## DEPARTMENT OF PARKS AND COMMUNITY SERVICES

December 8, 2023

**Subject: Mayberry Filing No.2A - (VR2323)**

VACATIONS OF PREVIOUSLY PLATTED LOTS, ROWs AND EASEMENTS IN MAYBERRY, COLORADO SPRINGS FILING NO. 2

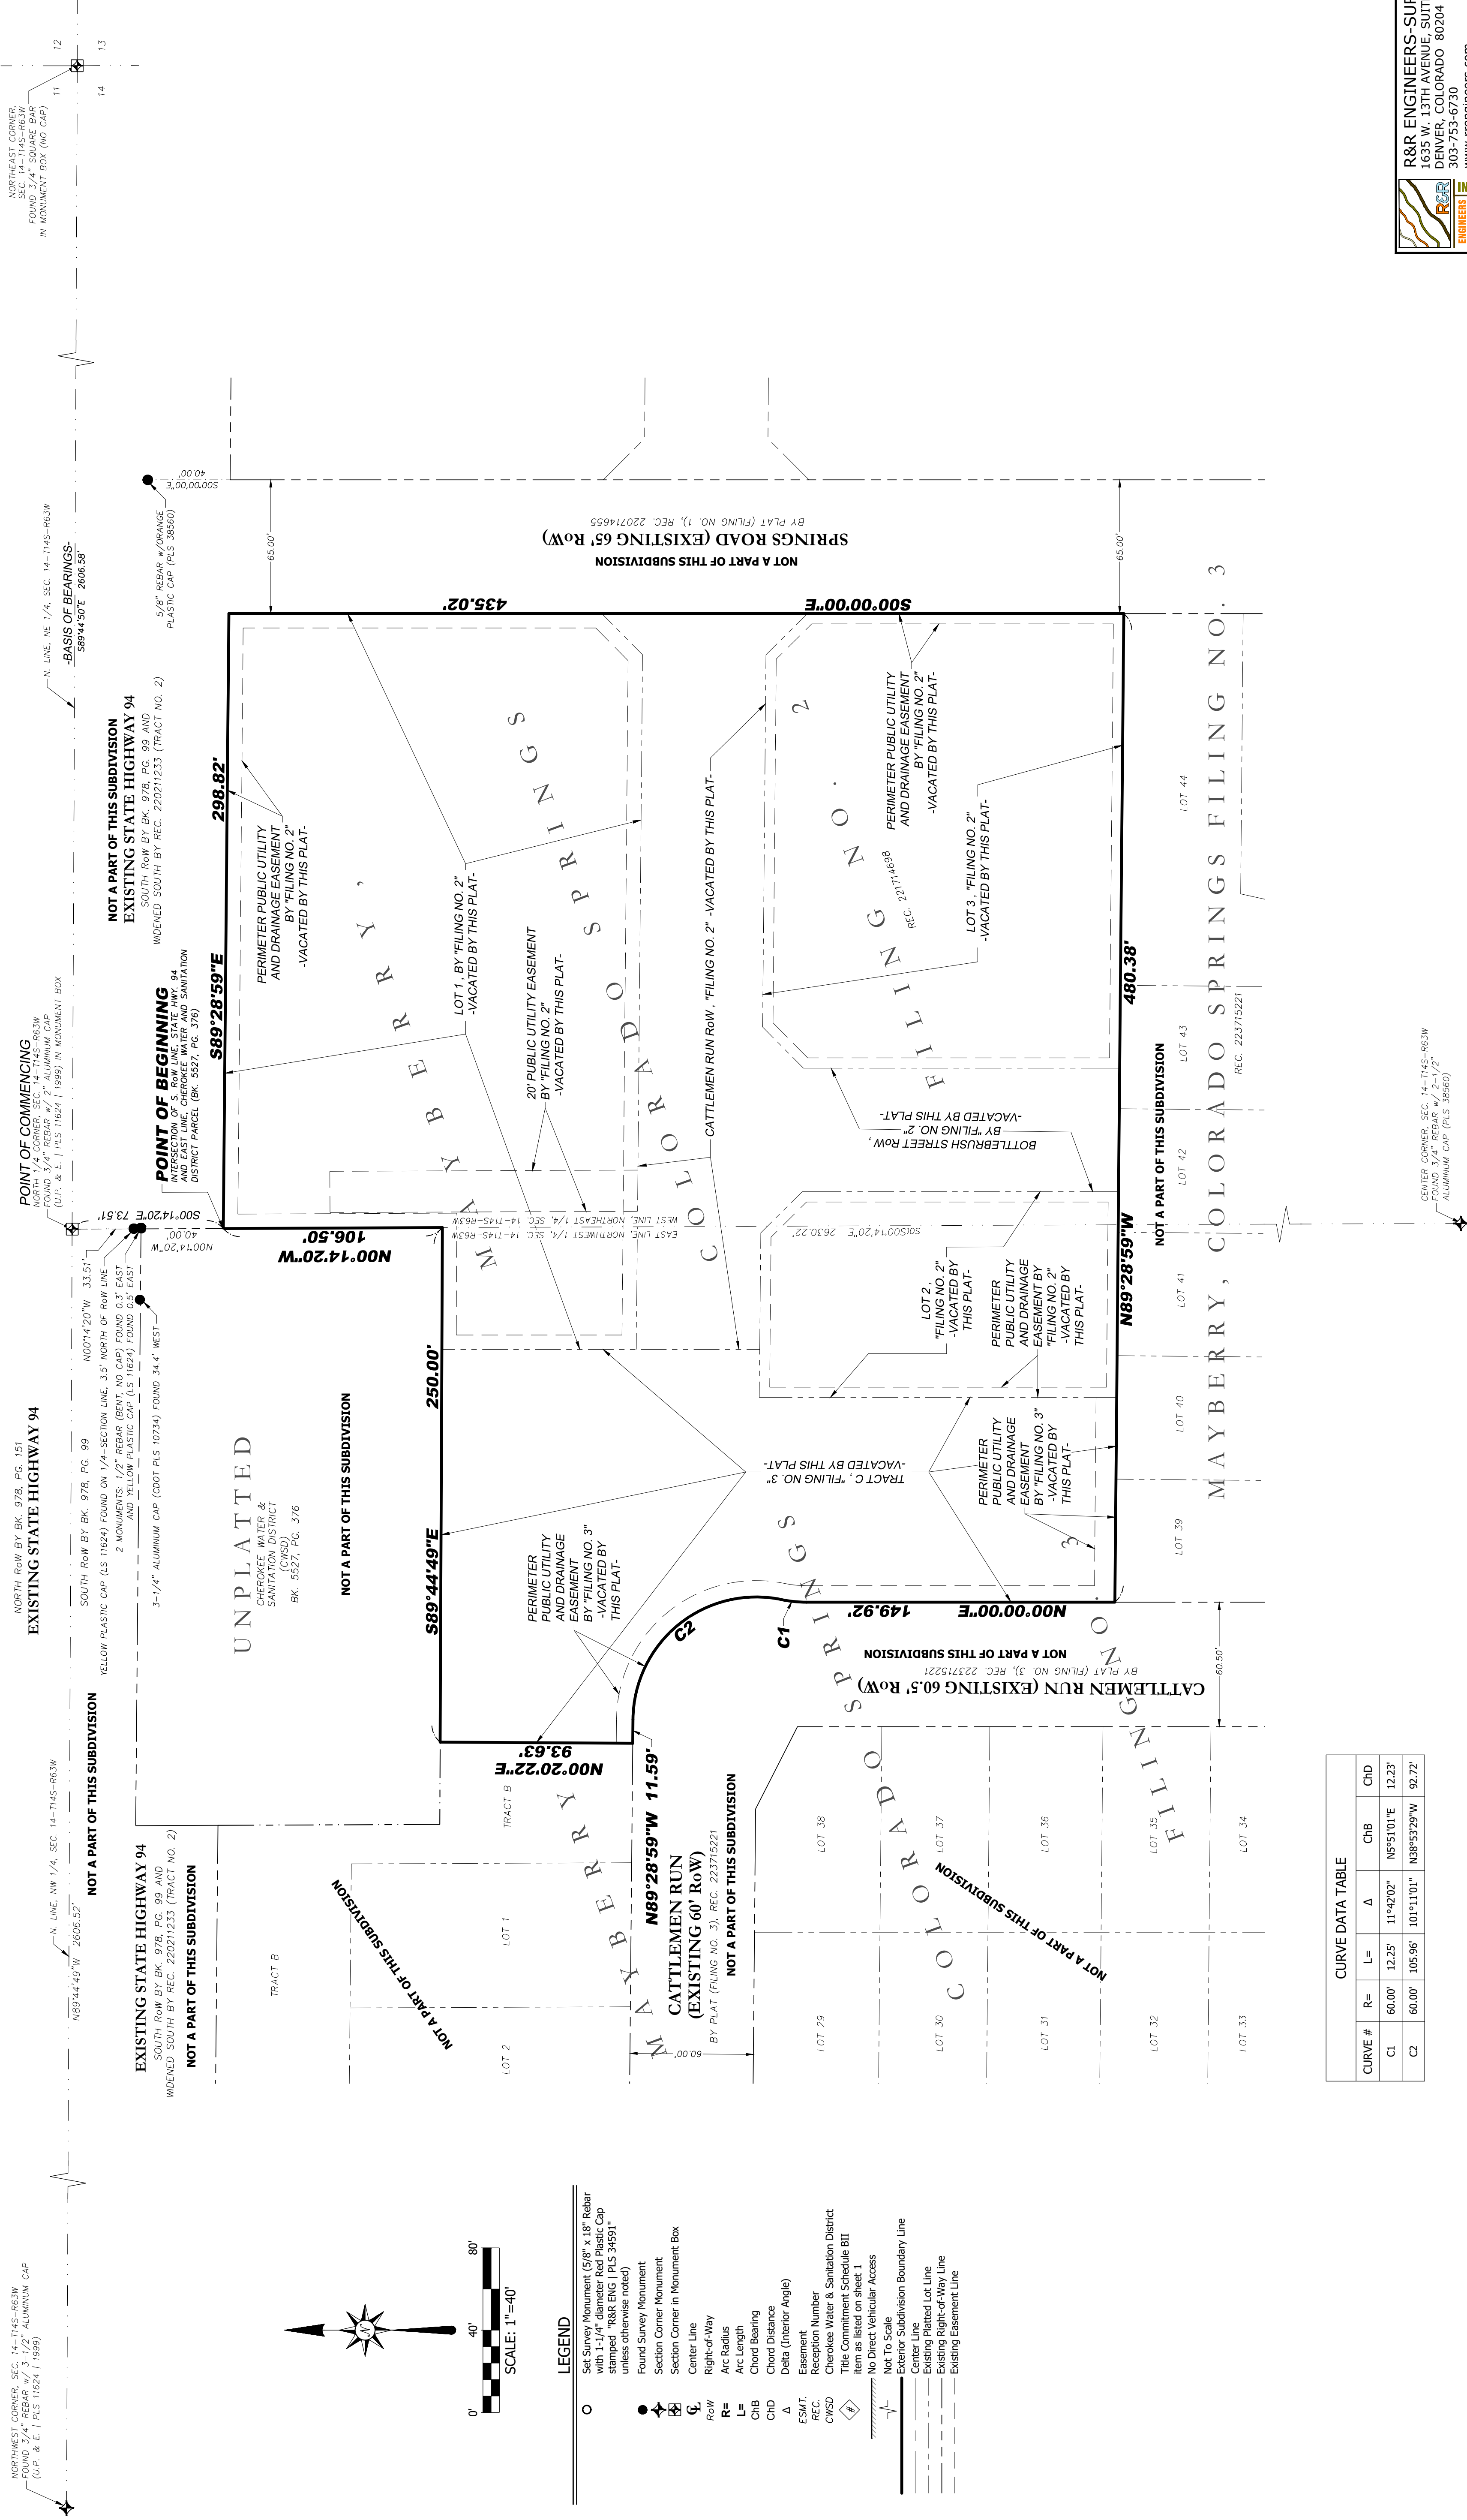
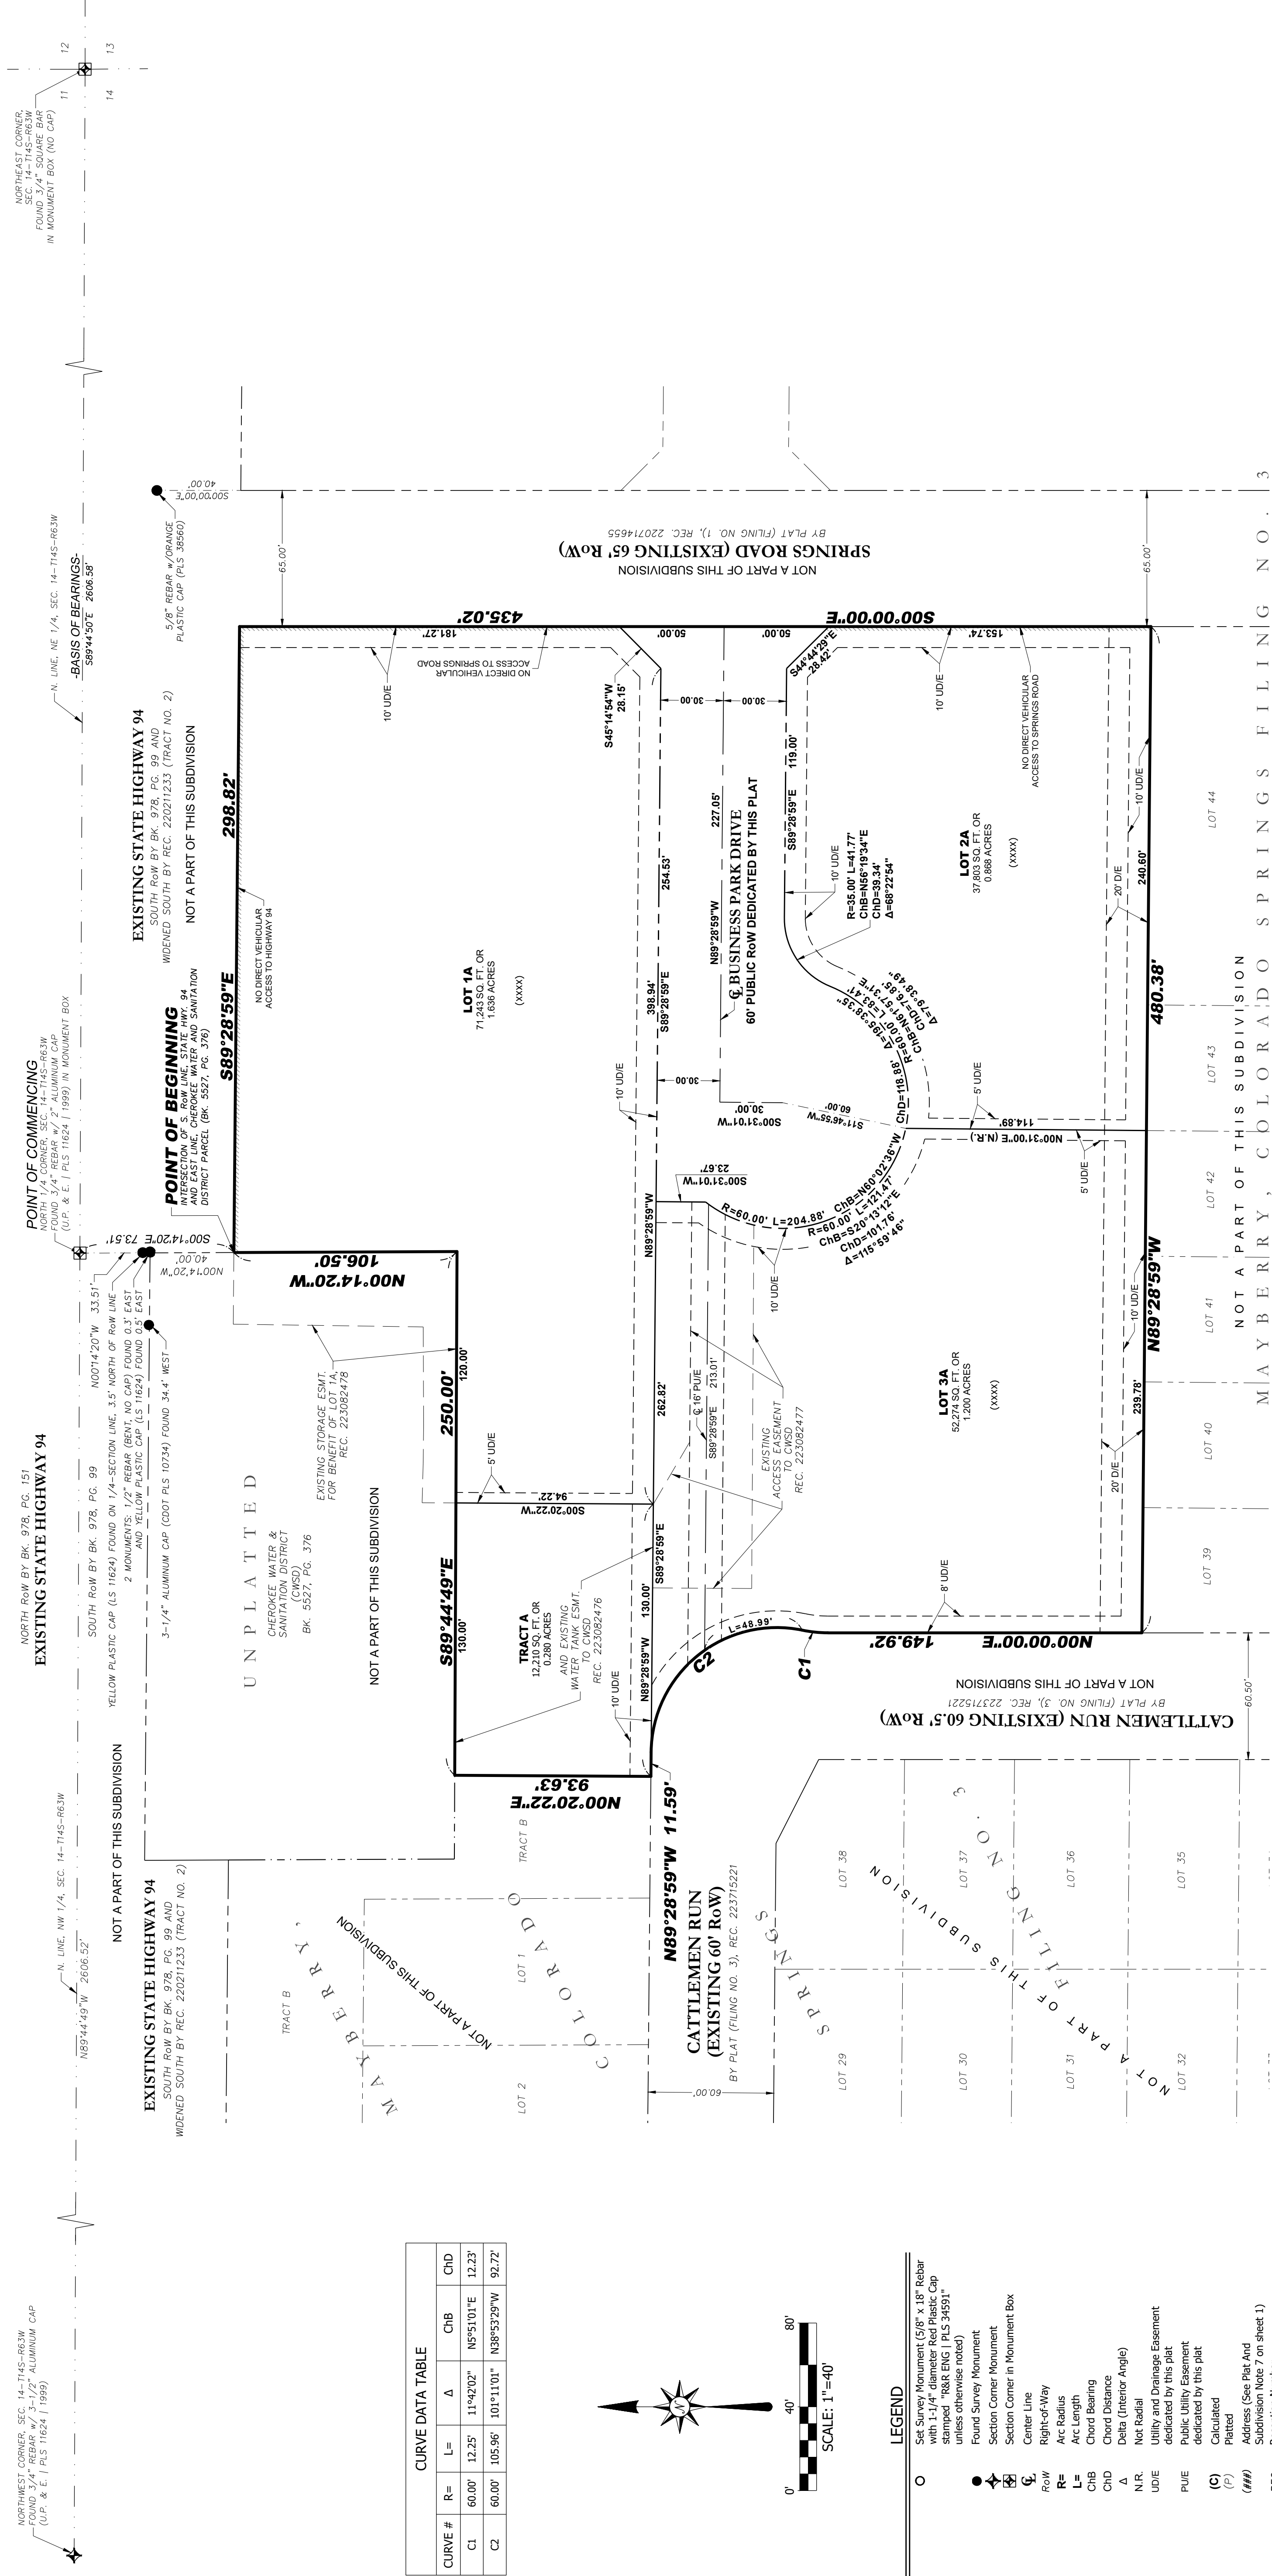
The El Paso County Parks Master Plan identifies two master-planned trails adjacent to the proposed facility. The proposed Highway 94 Bicycle Route runs east and west along Highway 94. This proposed trail will not be impacted by the project because it will be accommodated within the public right-of-way. The proposed Highway 94 Primary Regional Trail also runs east and west along Highway 94. This proposed trail would be impacted by the proposed facility because its alignment is on the south side of Highway 94. The Highway 94 Regional Trail alignment was previously dedicated to El Paso County on Mayberry Filing No.2. However, the trail easement is not shown on the proposed replat. The Highway 94 Regional Trail shall be labeled and shown on the final plat.

County Parks requests trail easements where development projects impact proposed County trails. As it pertains to this application, the County requests that the landowner provide a 25-foot public trail easement along the south side of Highway 94 and south of the Cherokee Water & Sanitation parcel to make a connection to the west that allows for the construction and maintenance by El Paso County of the Highway 94 Primary Regional Trail, and this easement shall be shown and dedicated to El Paso County on the Final Plat.

*Recommend that the Planning Commission and the Board of County Commissioners include the following conditions when considering and/or approving the Mayberry Filing No.2A Vacation and Replat: (1) Provide a 25-foot public trail easement along the south side of Highway 94 outside of the public right-of-way and south of the Cherokee Water & Sanitation parcel to make a*

*connection to the west that allows for the construction and maintenance by El Paso County of a Primary Regional Trail, and this easement shall be shown and dedicated to El Paso County on the Final Plat.*
